12 August 2019

Ms Susan Fox
Industry Assessments
Department of Planning, Industry and Environment.
GPO Box 39
SYDNEY NSW 2001

**Re: SSD 8593 - Proposed expansion of an existing resource recovery facility
No. 16 Kerr Road, INGLEBURN**

CATCHMENT PLAN
16 KERR ROAD,
INGLEBURN
BRS

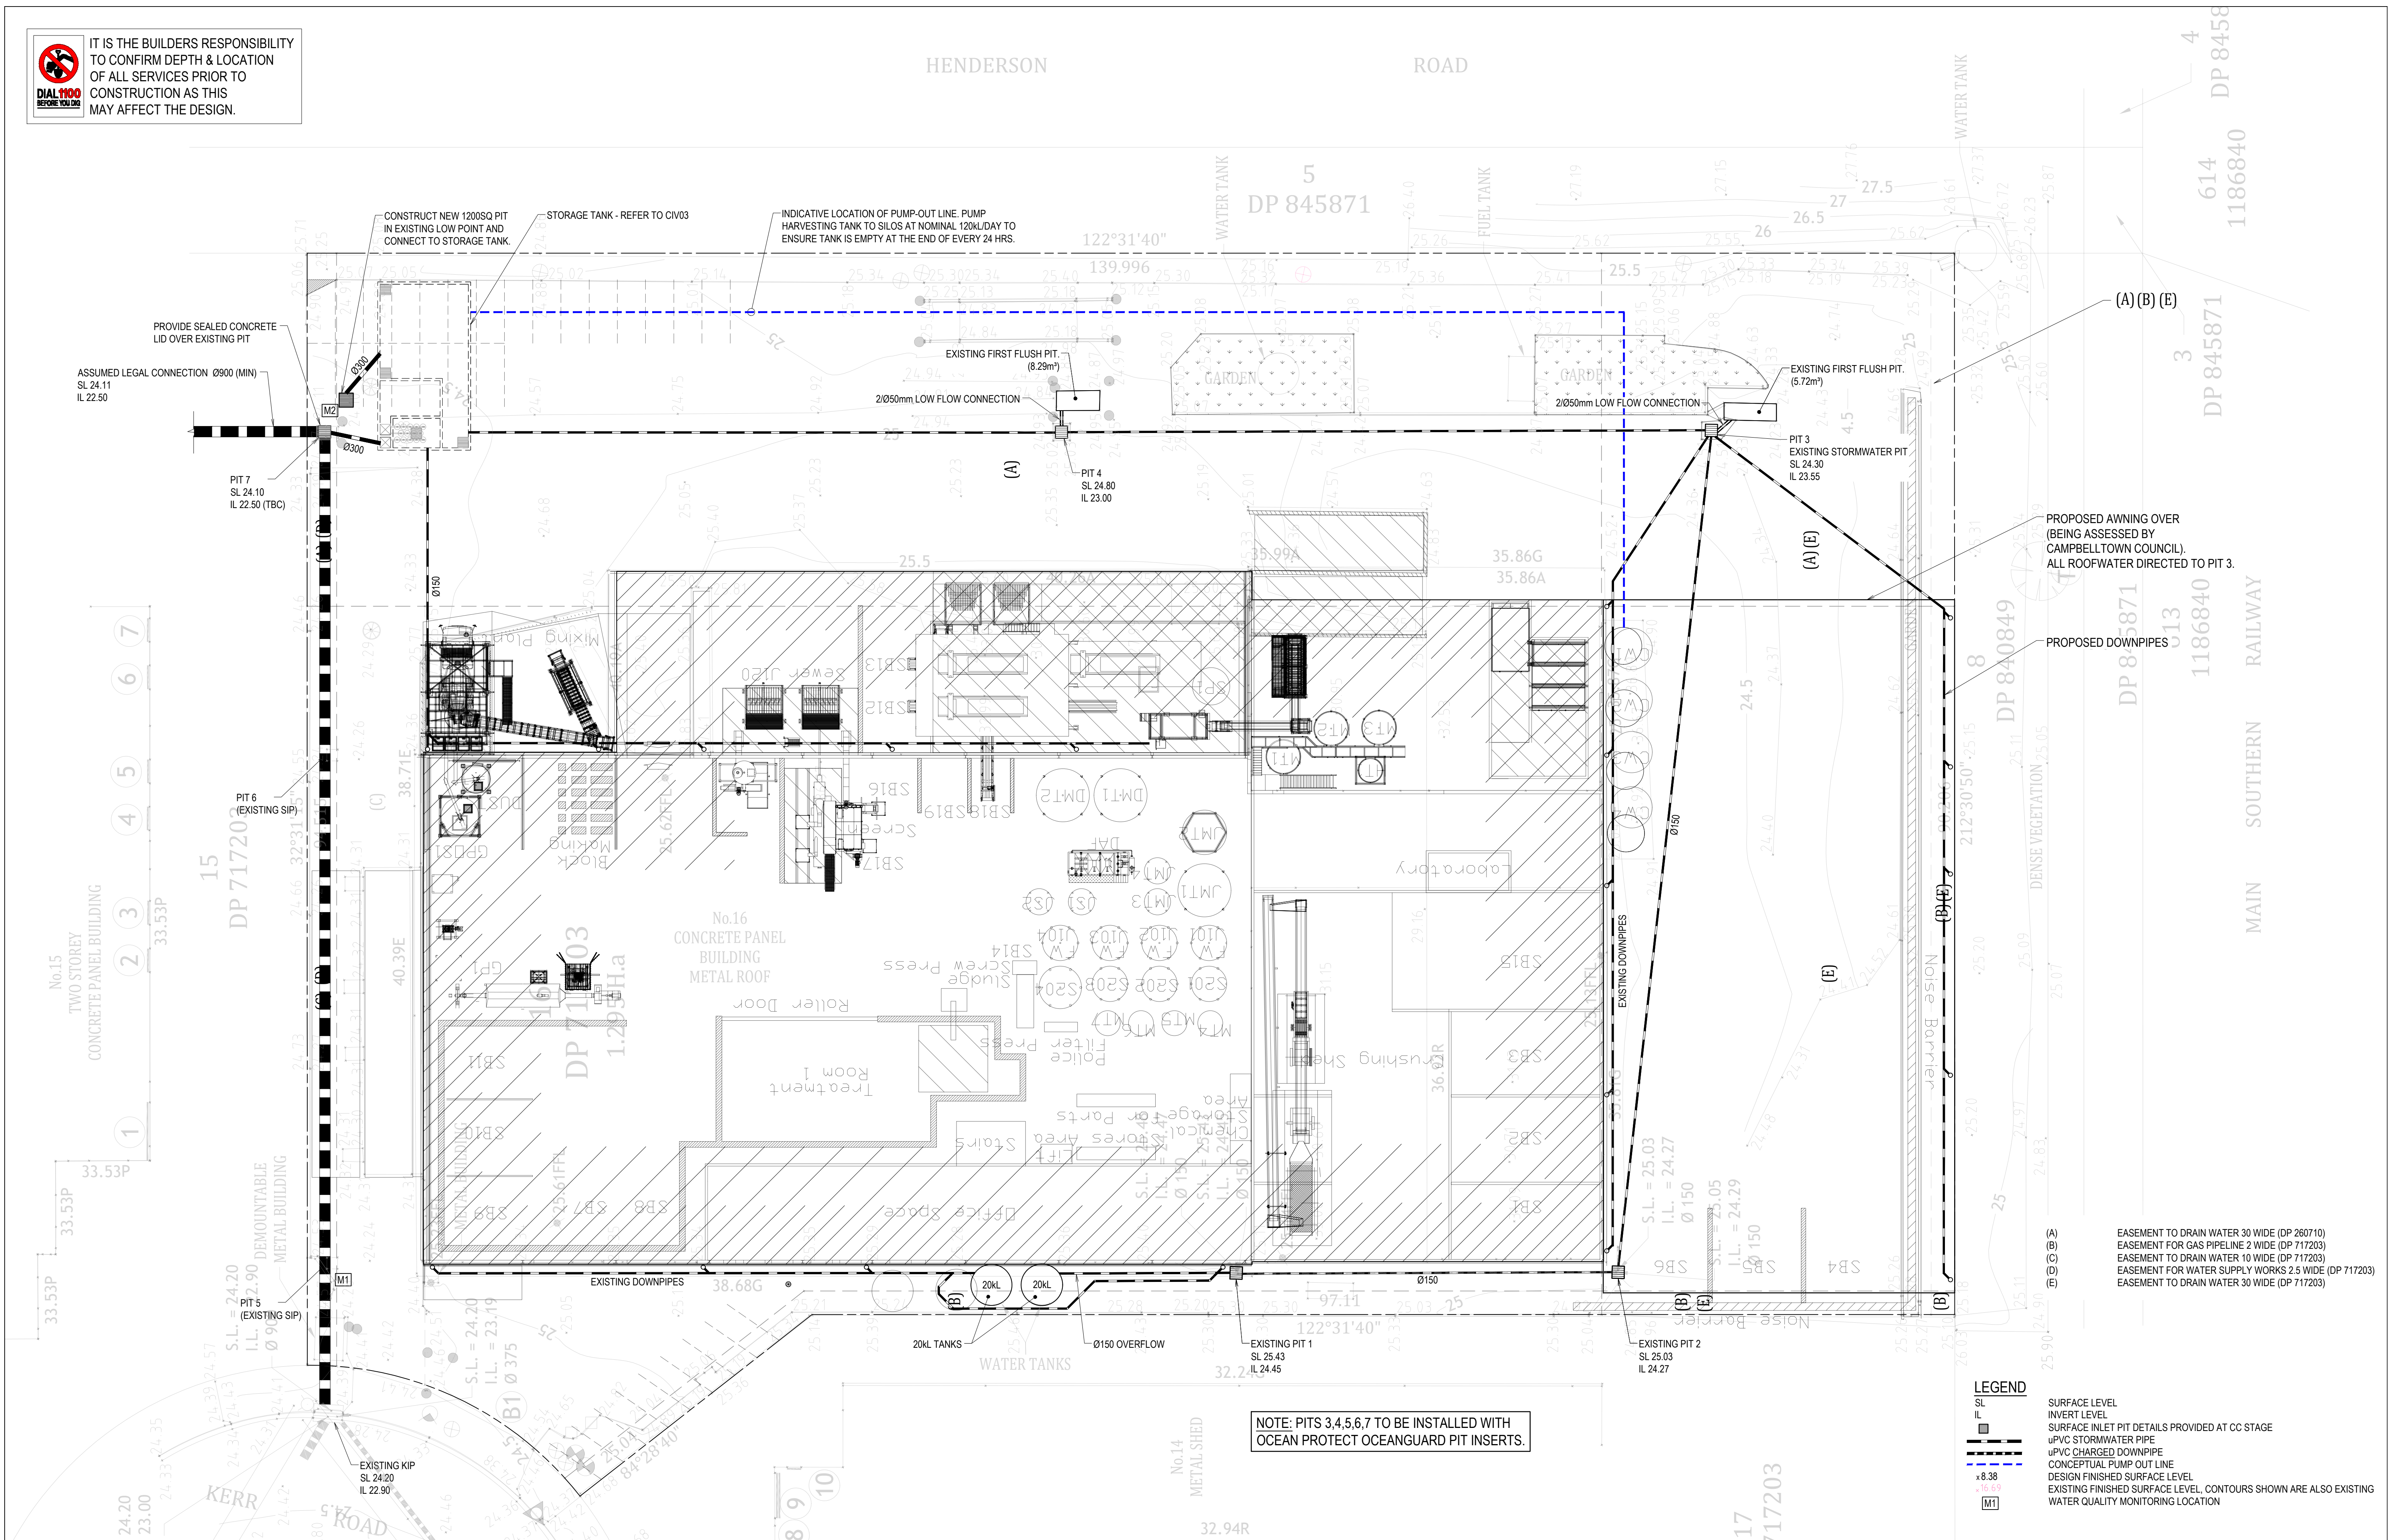
The proposed stock piles and associated bay walls and receivals area is within the 30m wide easement for drainage of water. These would have an impact on flood behaviour and potentially an adverse impact on neighbouring properties. The stockpiled materials and sump water are also likely to be mobilised in a storm event, potentially creating a detrimental impact on water quality. The stockpile and receivals areas must not be located within these easements. Works and storage in these areas appear to contravene a restriction on the land's title, which notes that 'no building, erection of structure, excavation, filling or alteration of surface levels is permitted.'

The finished goods bays which are located on the common boundary of the subject property with 14 Kerr Rd are considered likely to have a significant impact on flood behaviour. Council has undertaken modelling and determined that these works are likely to cause an increase in flooding on the upstream property (up to 200mm in the 20% AEP Event, and an additional 100mm in the 1% AEP Event), which is considered unacceptable.

With these matters in mind, it appears that operations across the site need to be reconsidered by the proponent. At the least, further detailed information and modelling on water control across the site must be provided by the proponent should the current site operations wish to be pursued as the easements to drain water are heavily relied upon for storage and other integral components of the development.

DRAWING STATUS		SHEET SIZE
NOT FOR CONSTRUCTION		A1
PROJECT REF No.	DRAWING No.	SCALE
180009	TURN01	1:250
		REVISION
		K

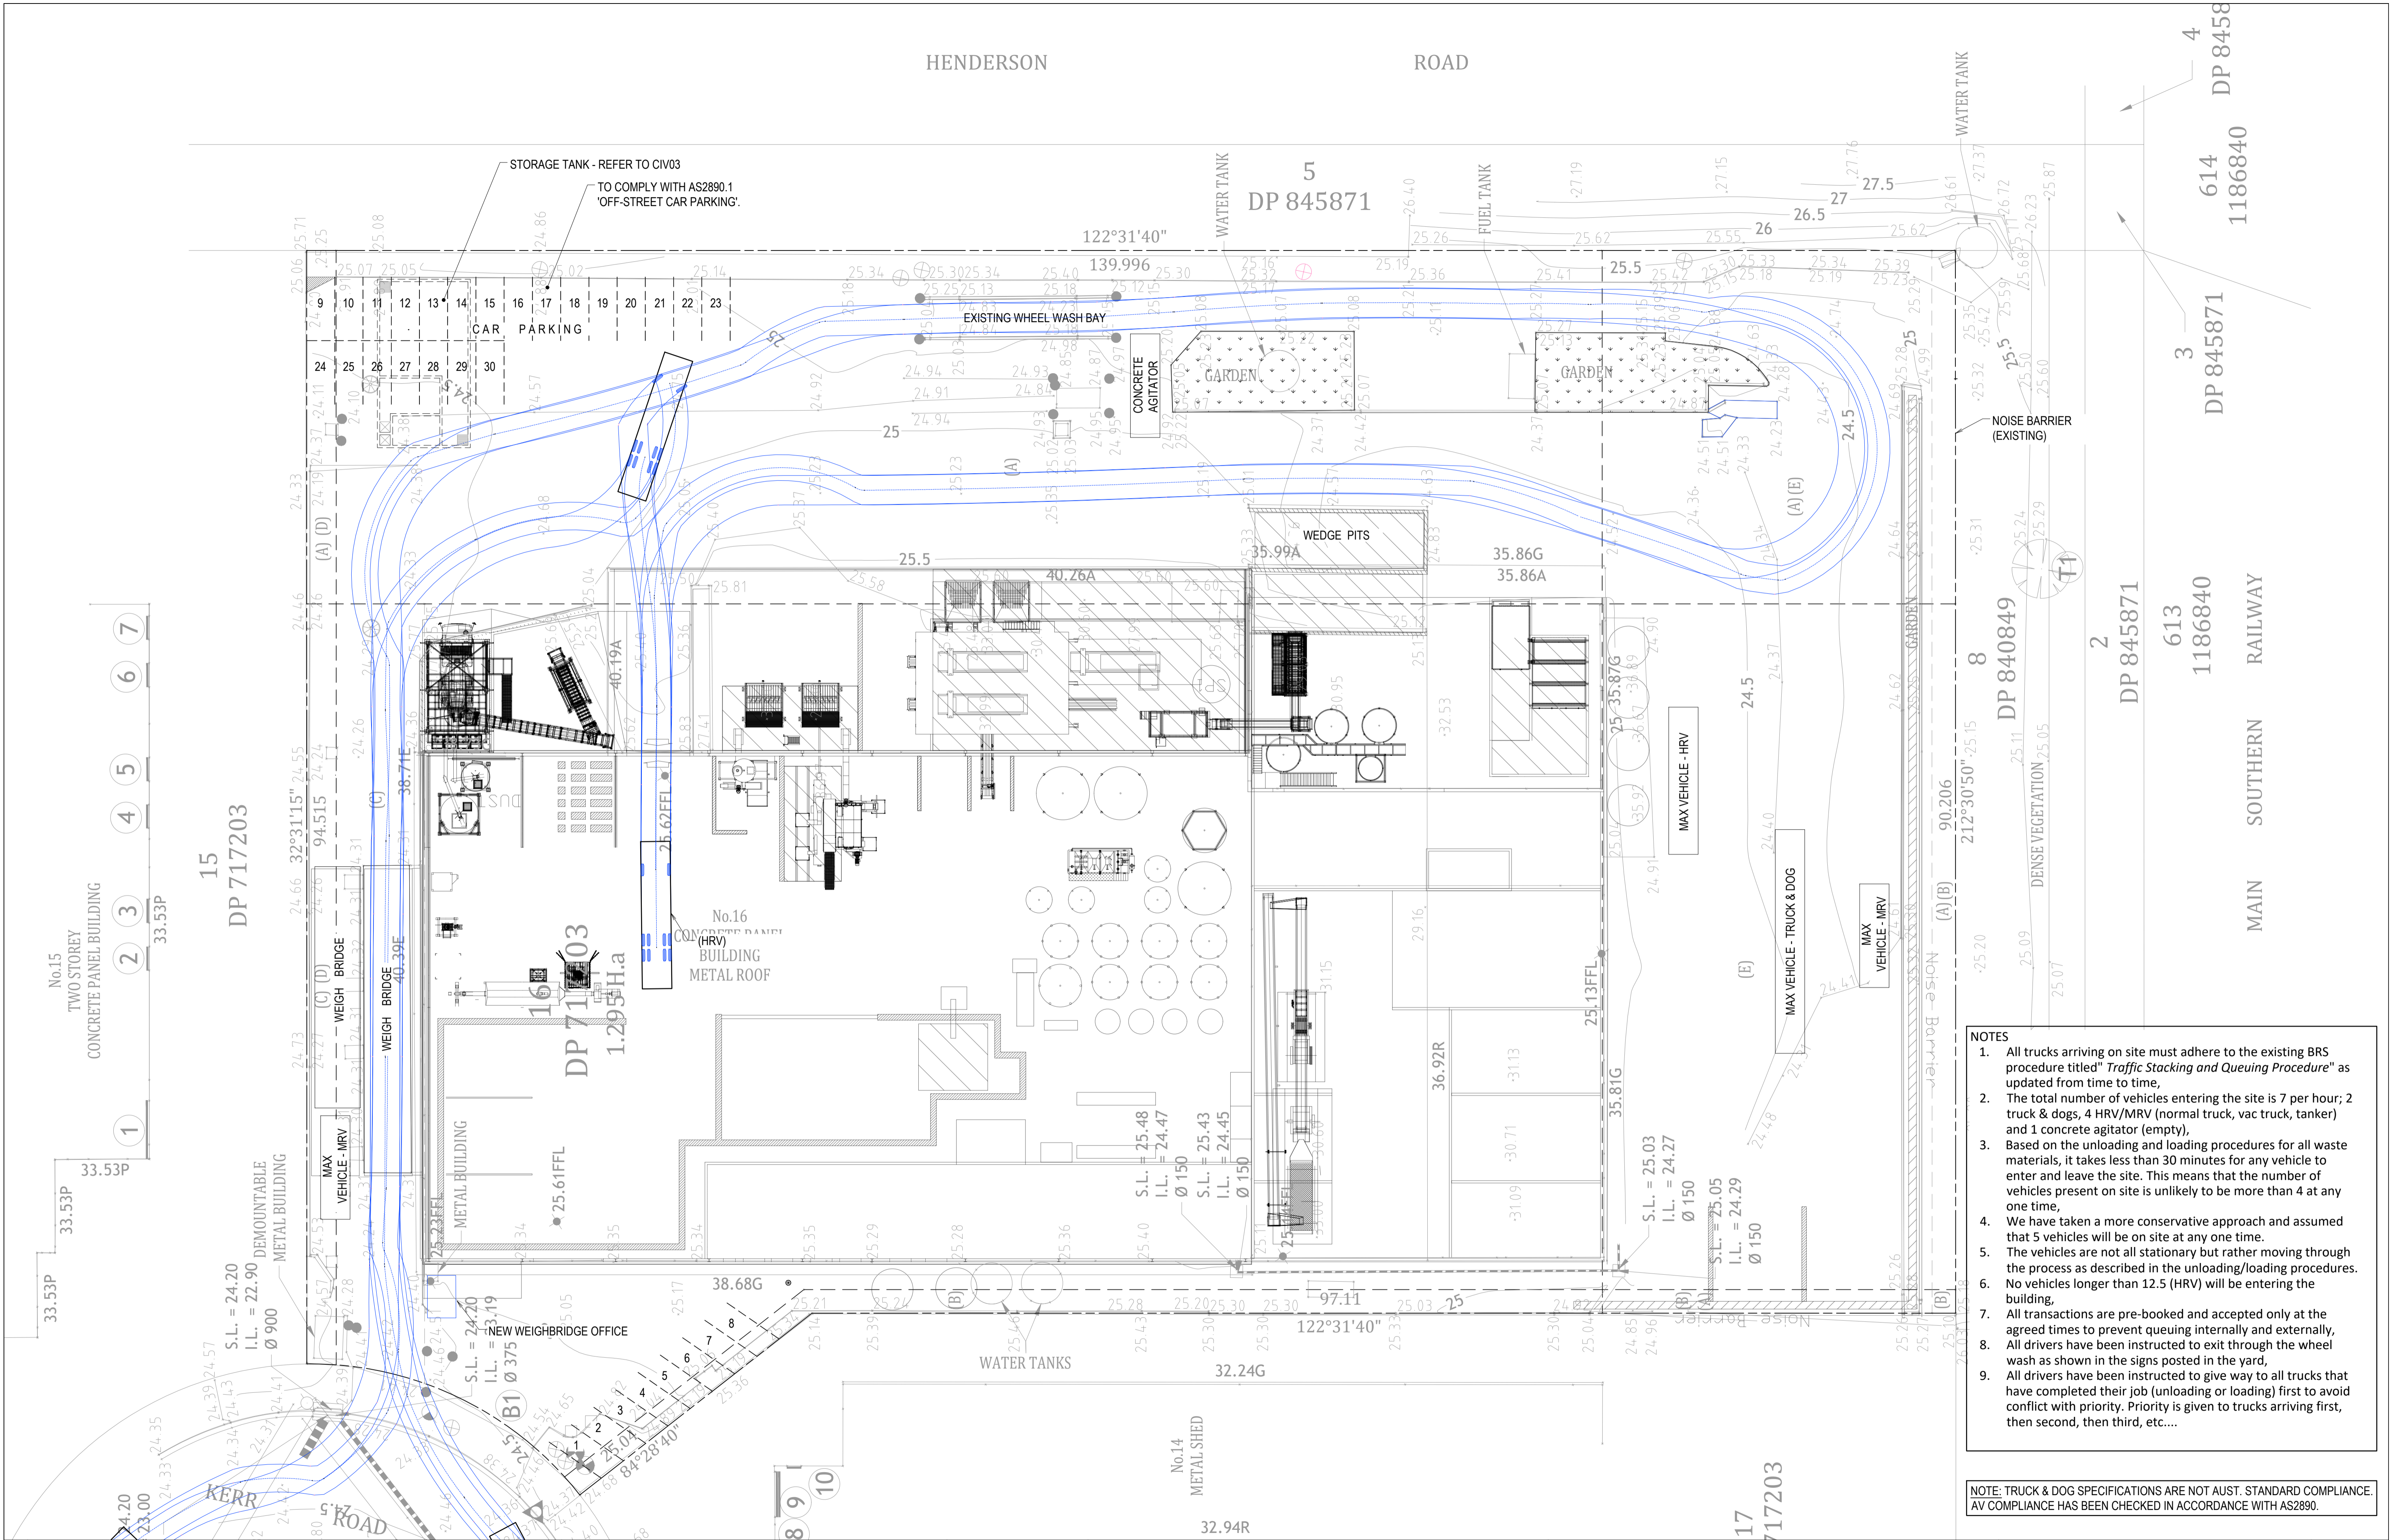
Council would also recommend further investigation/information be provided on the proponent's means for delivering materials inside the building, noting the size of the vehicles shown on drawings and the size/location of proposed stockpiles. Of particular interest is the means of loading/unloading at the hazardous AAS soils location. Reliance on a single medium rigid vehicle operating internal to the building does not appear to reflect regular operations at this and other similar waste recovery facilities and is not consistent with the pre-dominant transport vehicle for this type of waste, being the 'truck and dog' tipper.

As mentioned earlier, it is Council's position that (ideally) incoming waste would be deposited and sorted internally to minimise the transfer of noise and dust from the site.

If this is not practical (although it appears possible on the 'proposed site plan' that through routing of vehicles inside the building could be undertaken), it is recommended that all areas of the site where waste is to be stored and/or loaded, unloaded and relocated are to have misting systems installed which must always remain operational for dust suppression purposes.
